GORT PUBLIC REALM ENHANCEMENT PROJECT

AN COIMISIUN PLEANALA CASE NO. 323066-25

**GALWAY COUNTY COUNCIL RESPONSE TO
OBSERVATION BY:**

NATIONAL TRANSPORT AUTHORITY

PARKING ALLOCATION PLAN

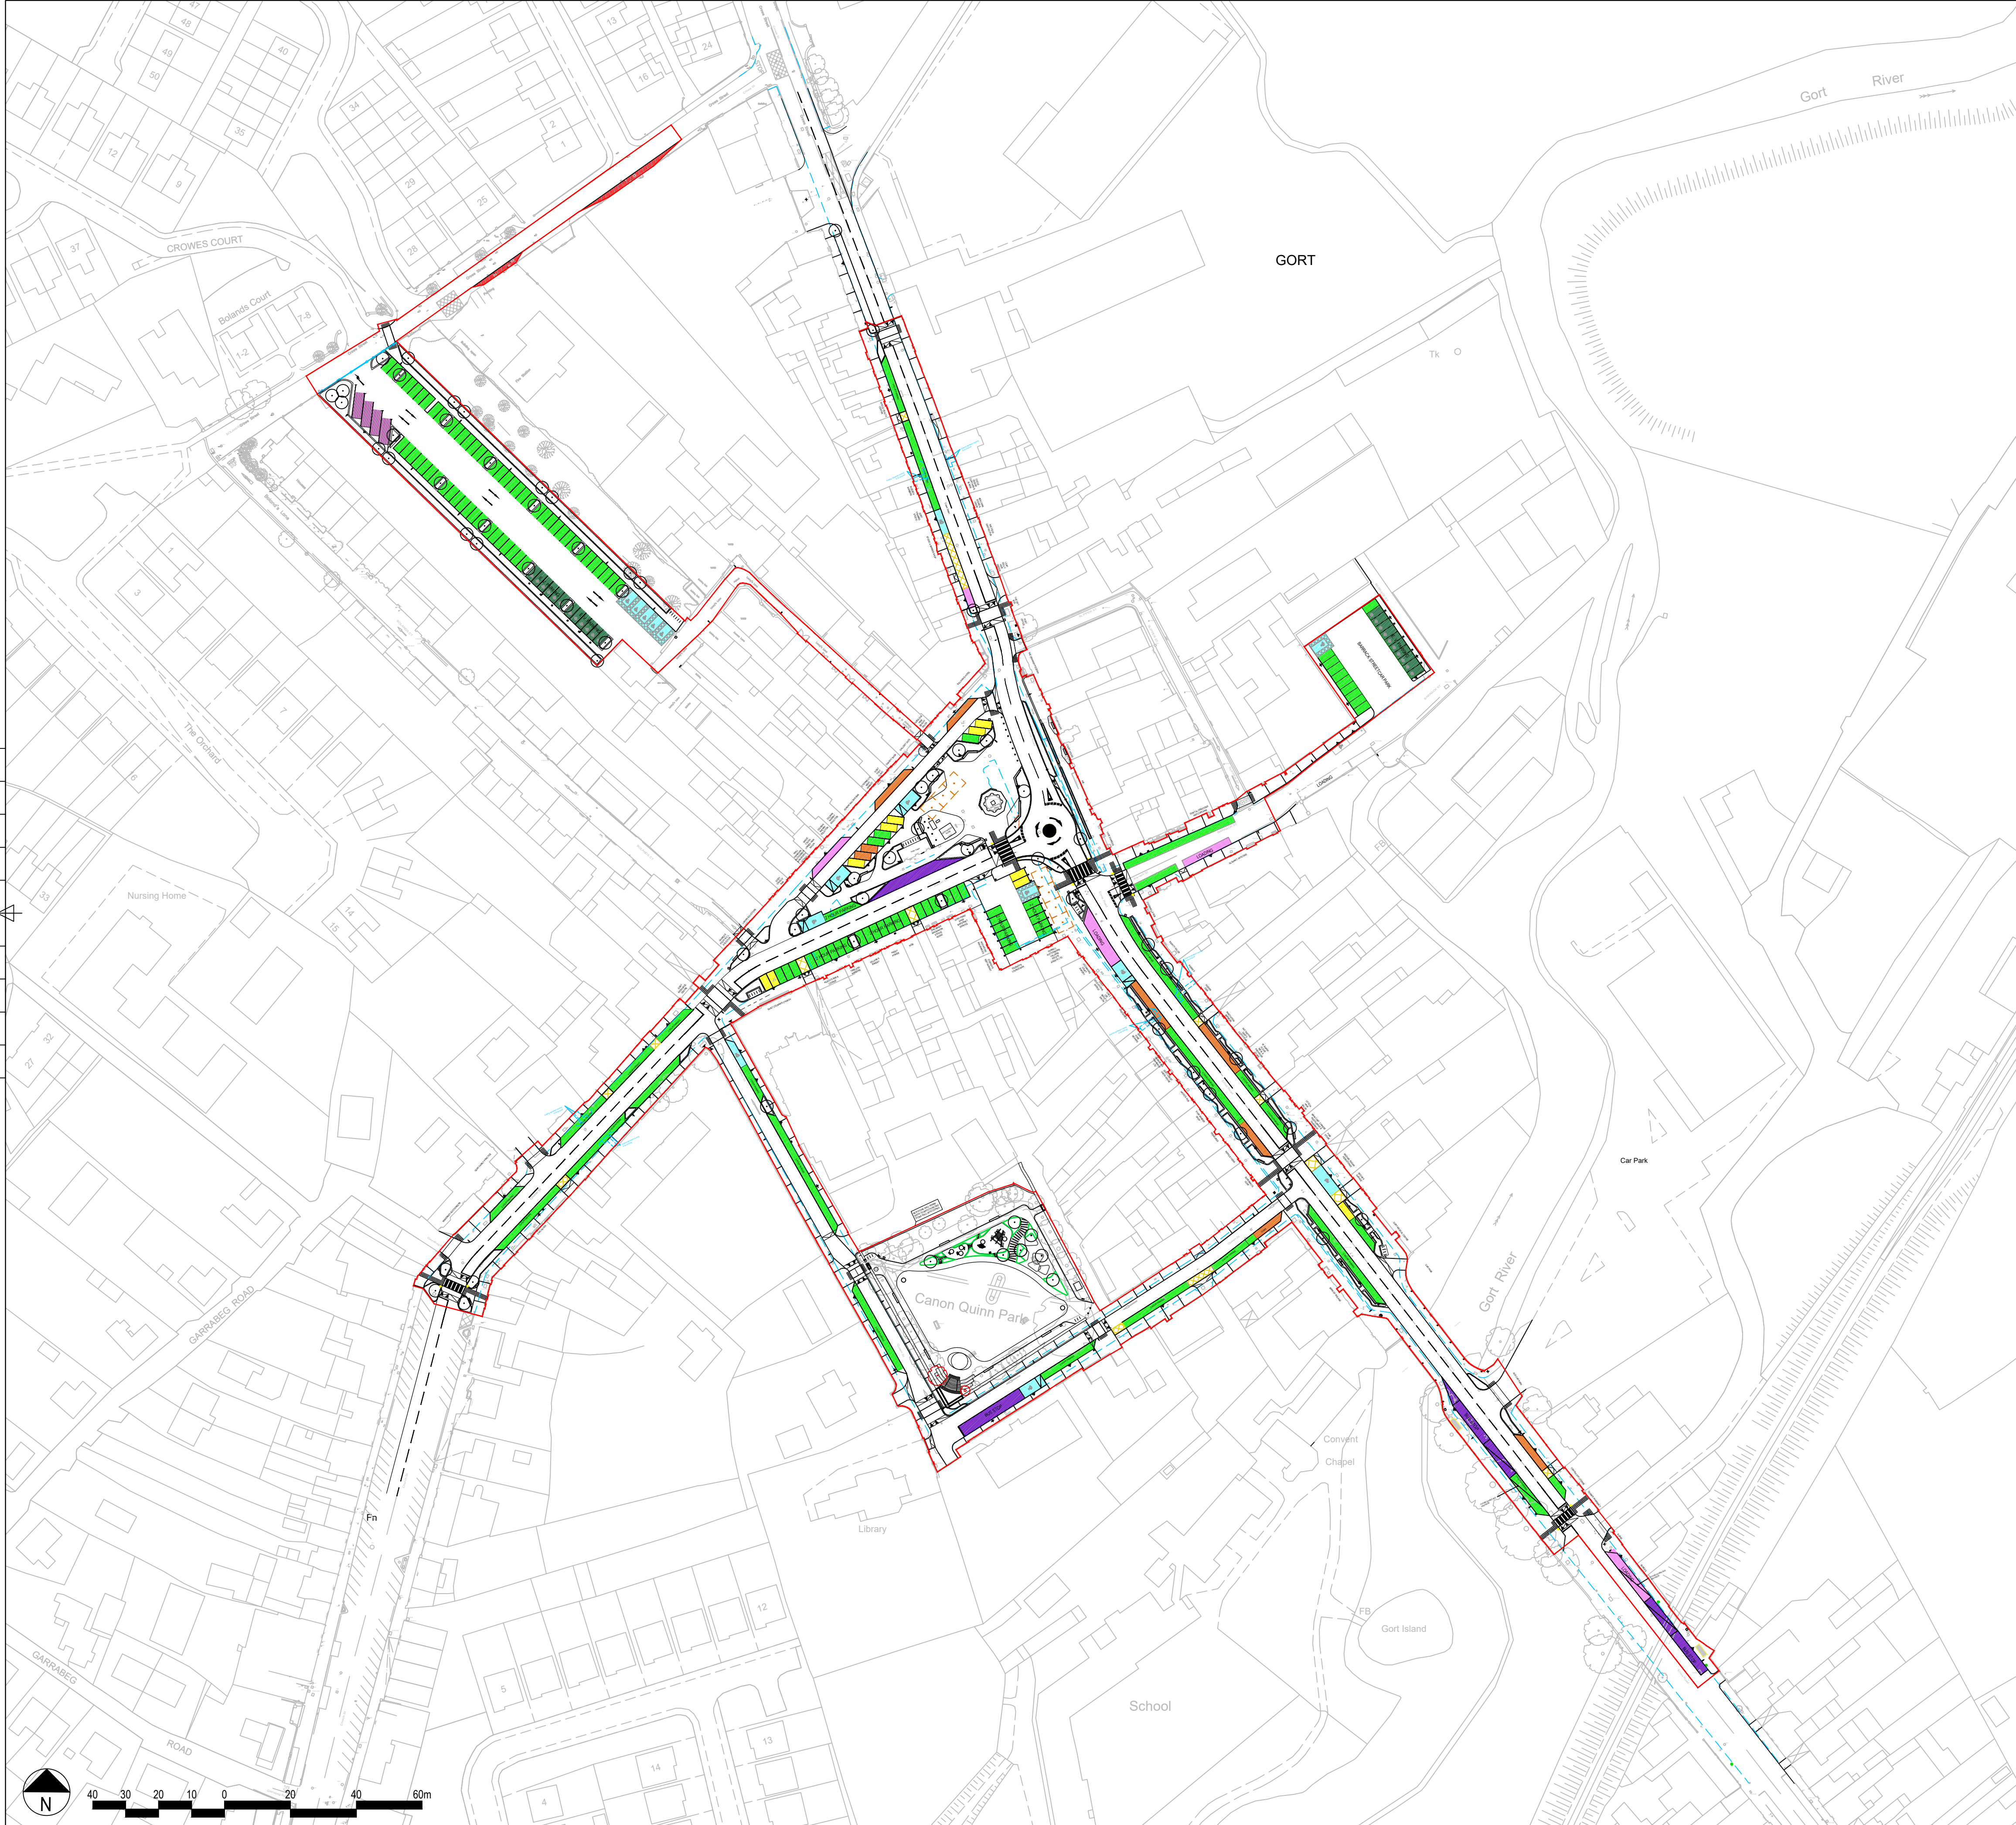
Regarding parking provision, Galway County Council provides the below figures which demonstrate a net gain in parking spaces of **13** number bays which includes **4** number RV bays (to meet a need identified through community consultation). We are open to reviewing parking provision in partnership with the NTA to ensure alignment with local needs and policy objectives.

Please note that the parking numbers quoted in the NTA observation are incorrect. The correct car parking numbers are as follows:

Within the project area there currently exists: **252** on-street car parking spaces.

The Planning Application proposes a reduction to **165** on-street car parking spaces.

This represents a **loss of 87** on-street spaces.

The proposed new Barrack Street off-street car park and new Lowry's Lane off-street car parks will accommodate a total of **100** spaces.

This represents a **net gain of 13** spaces overall (including 4 RV bays), or a **5% increase** on the current parking allocation. The proposed increase of parking bays includes the provision for 4 number RV bays in the Lowrys Lane off-street car park.

DRAWING TITLE
LANDSCAPE GENERAL ARRANGEMENT

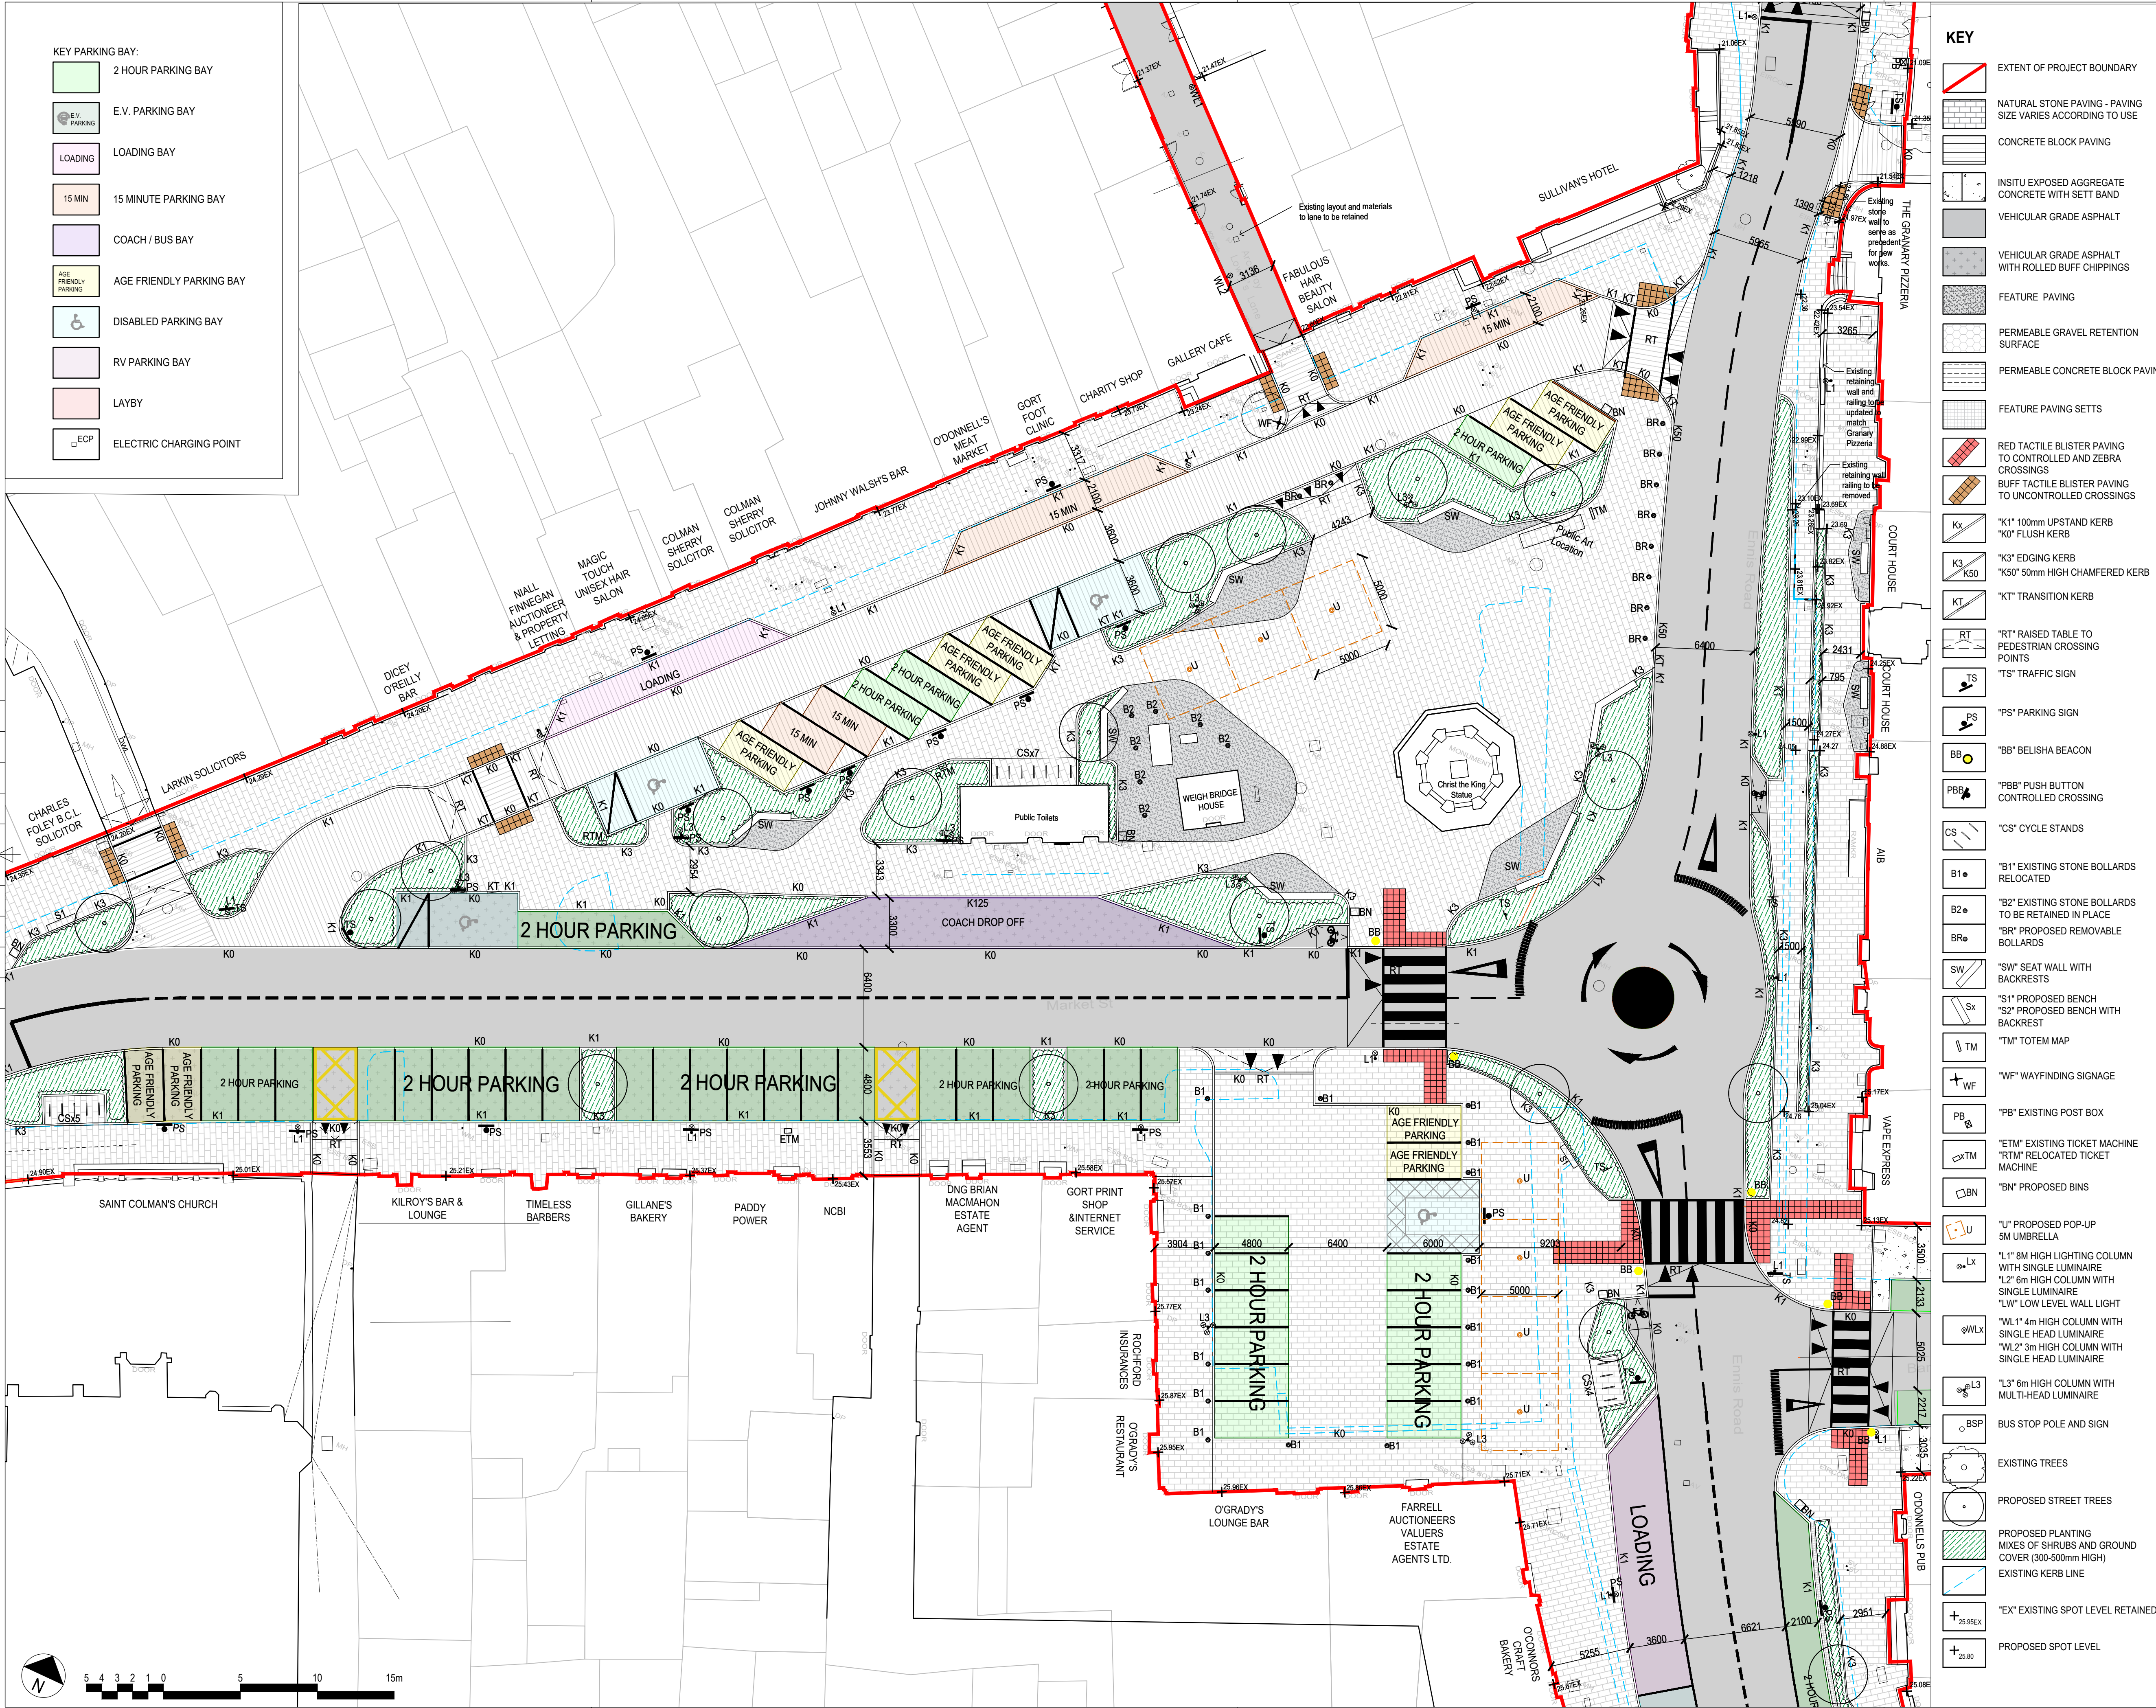
We acknowledge the NTA's concerns regarding the relocation of bus bays and the need for safe, accessible public transport for all, including elderly persons, children, and those with limited mobility. Galway County Council shares these priorities and highlights that the current arrangement at Gort Market Square presents safety and accessibility challenges, as evidenced by our analysis and community feedback.

The location of the Bus Stops, at the centre of the junction of the R458 and R460, at the Gort Market Square (Photo 1), causes significant traffic management and pedestrian safety issues (Photo 2, 3 & 4) in combination with universal accessibility issues (Photo 5 & 6).

In order to meet Bus Éireann's need Galway County Council proposes to relocate the bus stops to a position where enlarged, double bus bays which can accommodate two busses simultaneously can be developed.

Image 1: The GCC Planning Application drawing DR-L-0107 which illustrates the provision of a double bus bay on the north bound service which allows for future growth of bus services.
